**Consultation Response from KC,
Highways Development Management**

2025/93433 197, Westgate, Almondbury, Huddersfield, HD5 8XN

Formation of vehicular access (Listed Building within a Conservation Area)

Responding Ref: K6-14NE/8

Block Plan
1 : 500

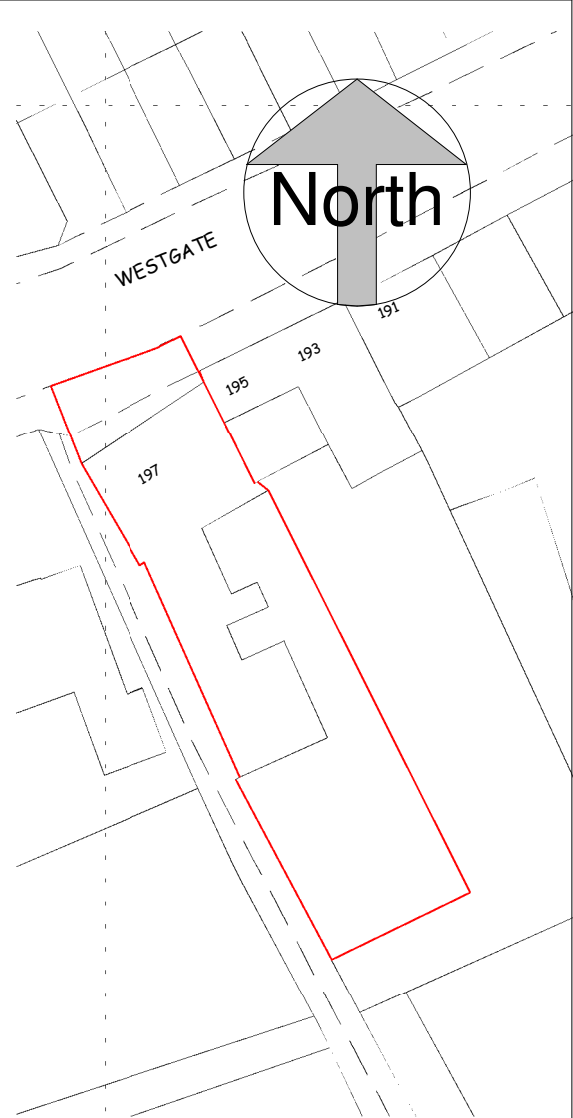
This application is for a parking space to be located on the footway outside No 197 Westgate Almondbury,

Whilst the dimensions of the parking space meets the minimum size required, it is at such an angle that it would be difficult to access with a vehicle.

There is an existing telegraph pole to one side and the boundary fence of the neighbouring property at the other side. Both of these impede a vehicle accessing the space safely

A public footpath emerges onto Westgate at this location and would be obstructed by a vehicle parked in this area

I would consider that, in practice, a vehicle parked on the footway in this location would both overhang the adopted footway and obstruct the public footpath to the detriment of the safety of pedestrians using both the footway and public footpath.
